**CITY OF ALBUQUERQUE  
PLANNING DEPARTMENT  
August 1, 2007  
DRB Comments**

**PROJECT # 1006701**

**RE: Tract 5, Town of Atrisco Grant, ROW 1, Unit B**

**DEVELOPMENT REVIEW BOARD – SPEED MEMO**

SKETCH PLAT OF TRACTS 5-A, 5-B AND 5-C ROW 1, UNIT B TOWN OF ATRISCO GRANT

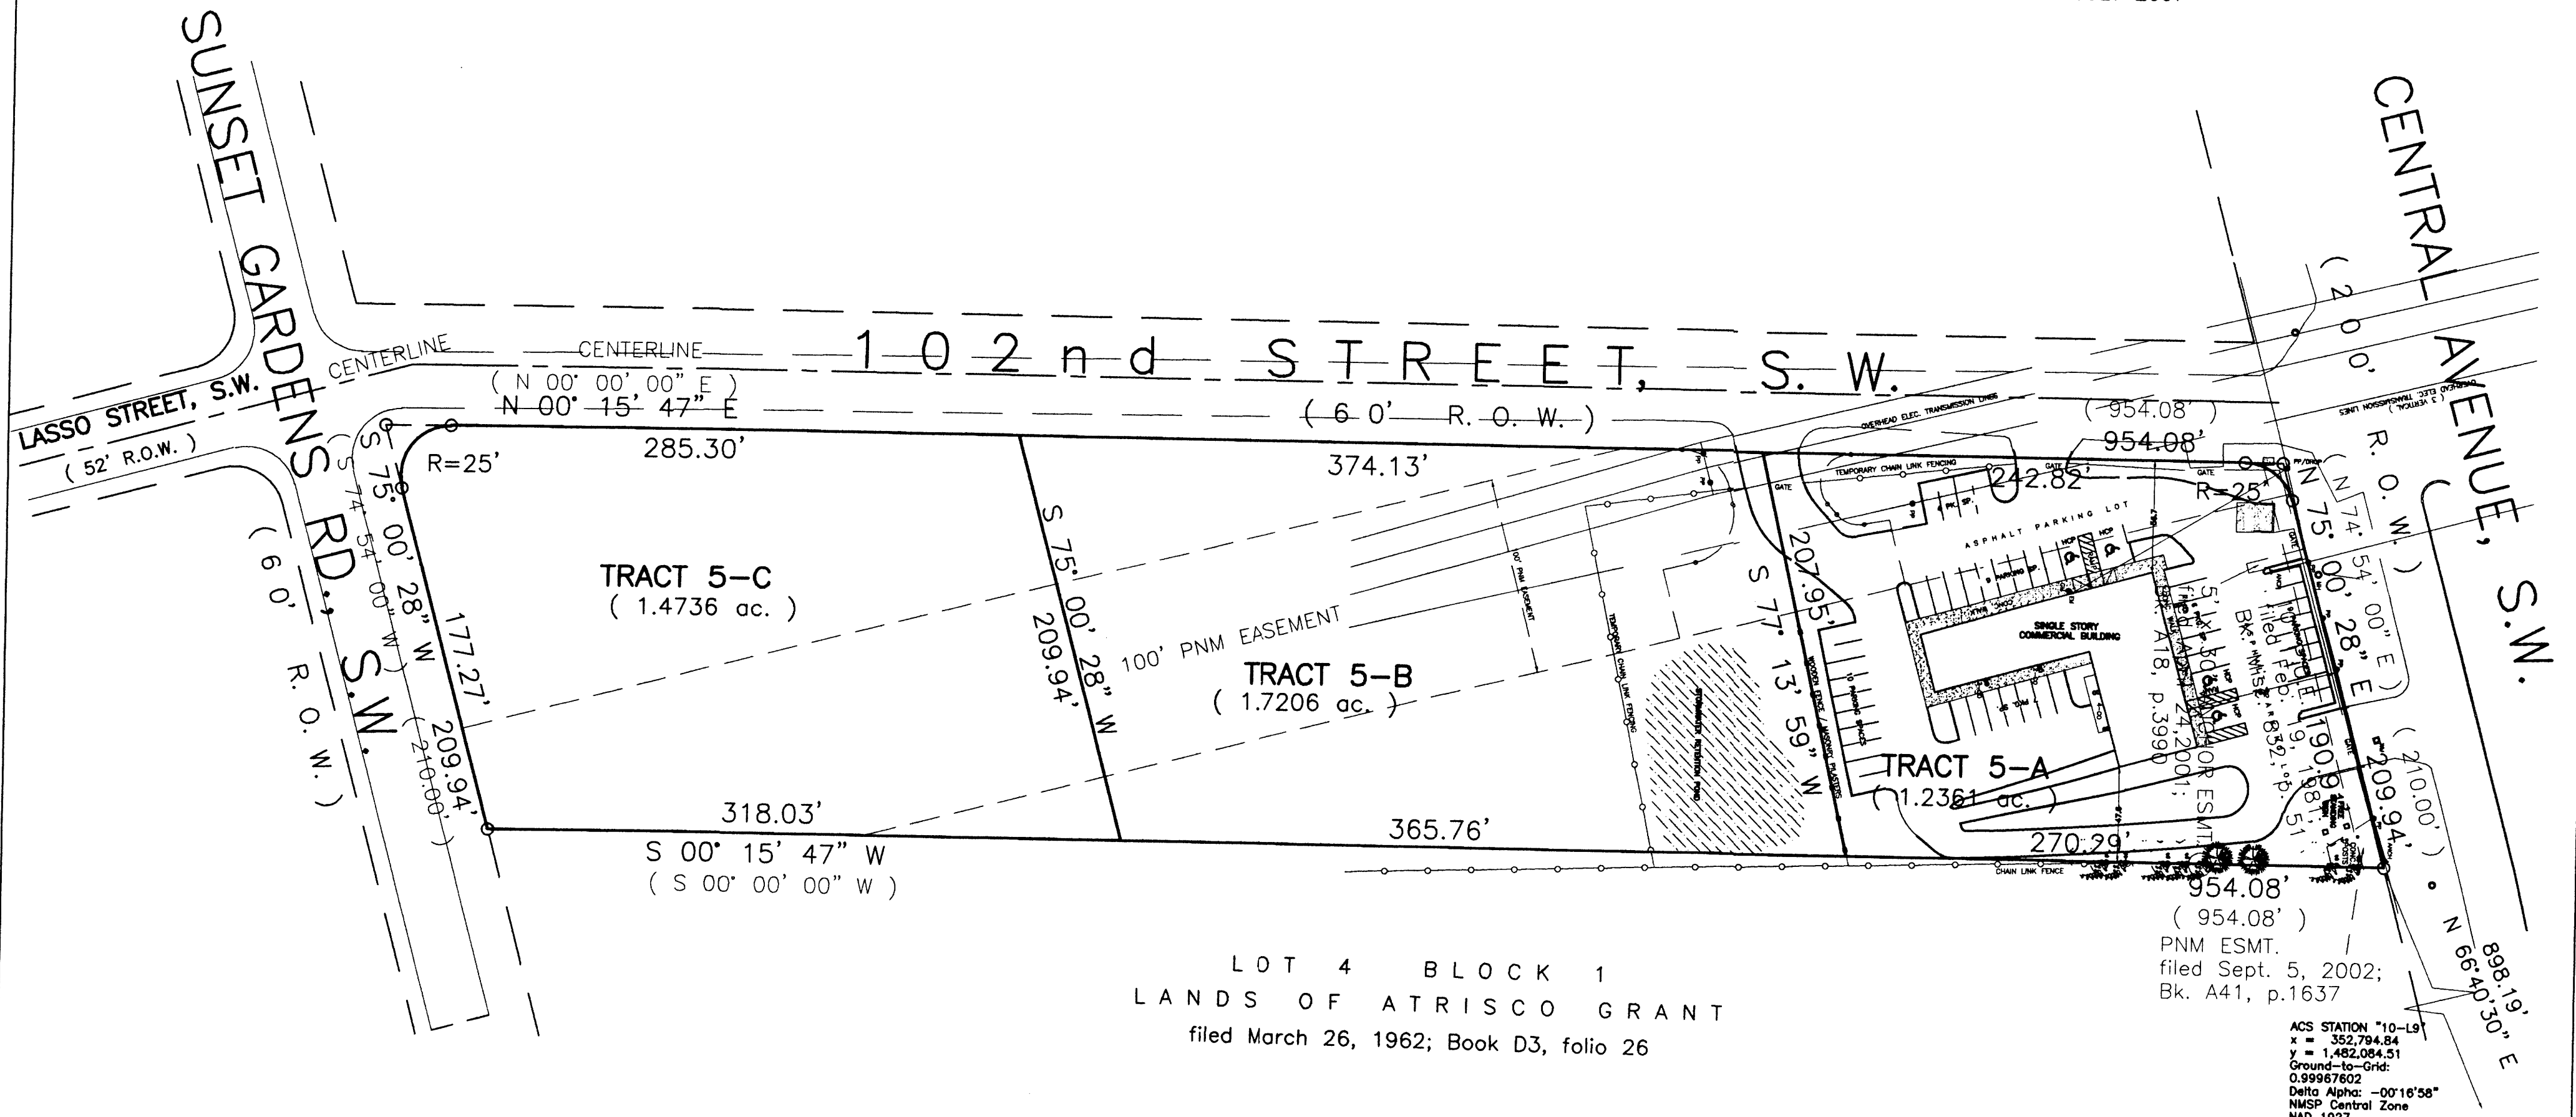
1. There are no water/sewer lines in 102<sup>nd</sup> Street.
2. There is no existing water/sewer account for the existing development, one must be established.
3. Must request a water/sewer availability statement.

| <u>No.</u> | <u>Comment</u>   |
|------------|--|
| 2)         | The radius from Central should be 30'.   |
| 3)         | Sidewalks will be required. (Unsure if curb and gutter will be required on Central.) |
| 4)         | Does the applicant have a NMDOT permit for the access onto Central?                  |
| 5)         | The alignment of Lasso Street may require additional dedication.                     |
| 6)         | The DPM requires 102 <sup>nd</sup> and Sunset Gardens to be 61' of R/W.              |
